**From:** Tom Rickman  
**Sent:** 12 September 2023 16:31  
**To:** Chris Wentworth  
**Subject:** RE: Oxfordshire County Council response to 23/00916/DISC, Heyford Park, Camp Road, Upper Heyford, OX25 5HD

123 | SCALE: 1:5000 (0A1) | DRWG: P16-0631_129 SHEET NO: __ REV: D1 CLIENT: DORCHESTER GROUP

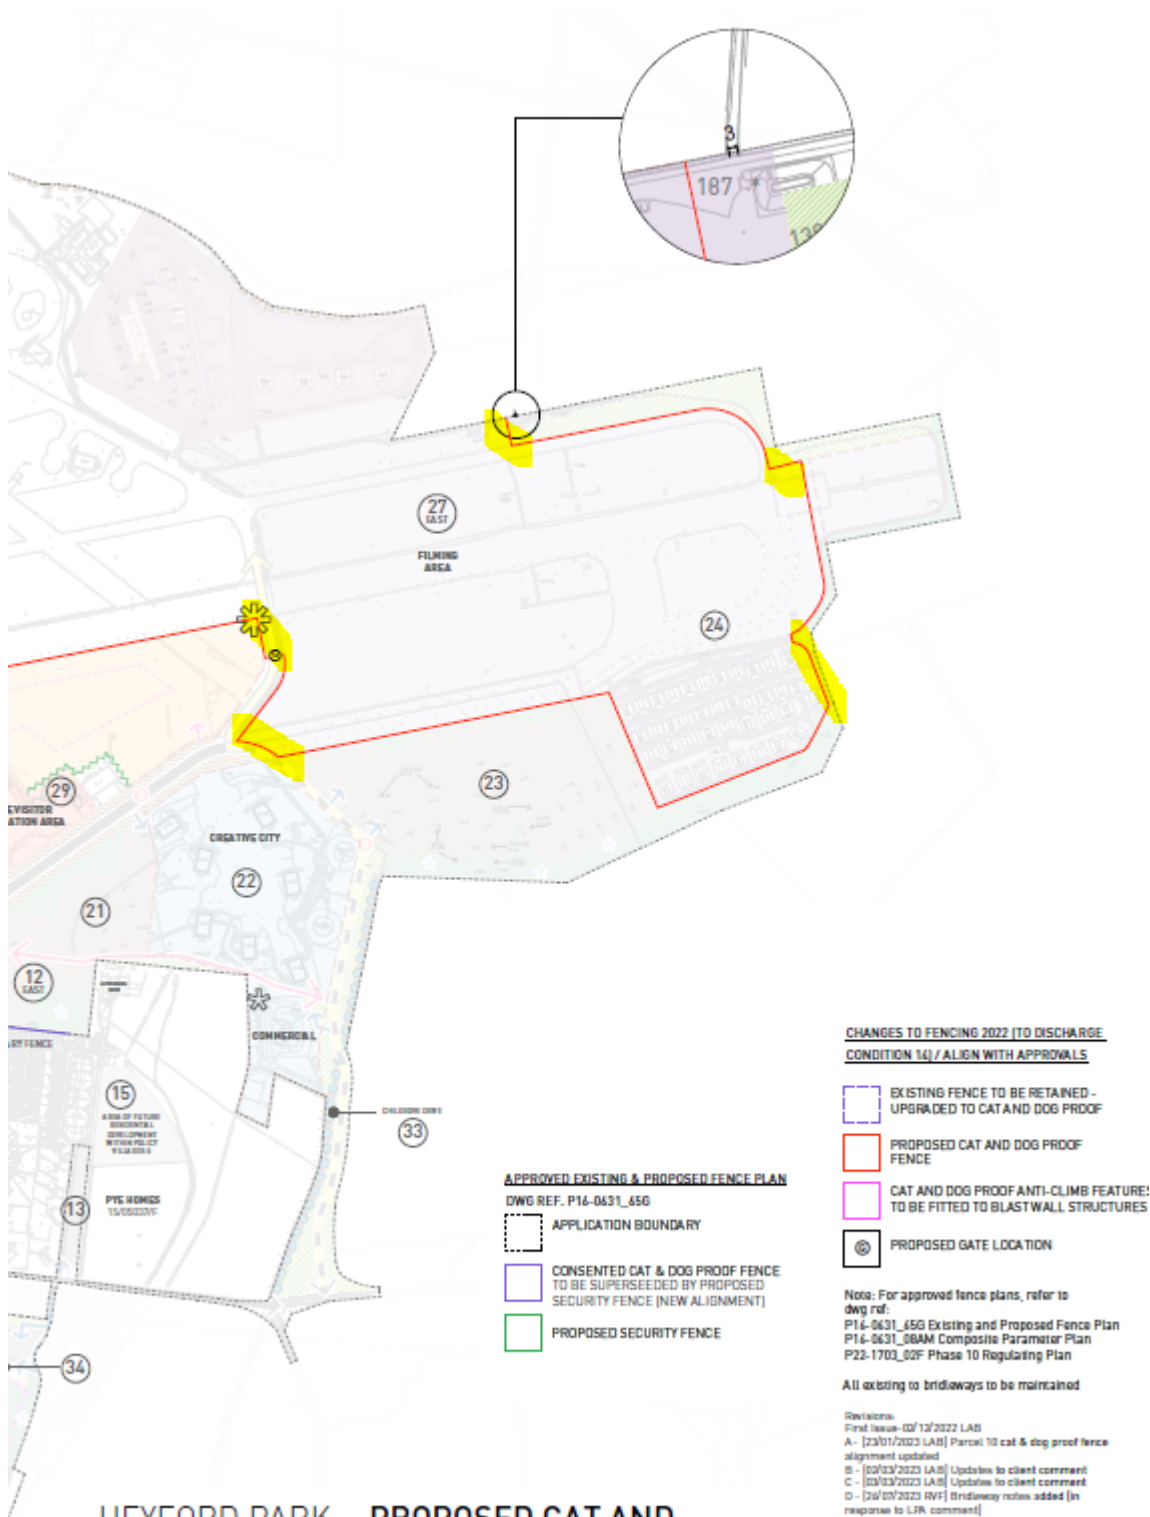
As I understand it, the Aves Ditch Bridleway would lie beyond (outside of) the perimeter of the proposed (cat and dog proof) fencing. However, as you referred to it would intersect (as circled green below) the 'existing fence' to the north east corner, which is to be upgraded.

Could you please annotate the relevant opening in the fencing, confirming the size of the opening, to ensure the Bridleway remains open.

With the above in mind, I note that the Aves Ditch Bridleway and Portway Bridleway intersect the flying field, to which the fencing strategy relates, at a number of points. Could you please provide an appropriate site plan to illustrate the respective junctions where the bridleways intersect the flying field and what form any fencing takes to ensure the bridleways remain open at these points.

Lastly, the extension to Chilgrove Drive to form the bus and HGV route. Could you please identify the junction where Chilgrove Drive intersects the perimeter fence line and the size of the opening to ensure it is fit for purpose. On receipt of the above I can then progress with OCC.
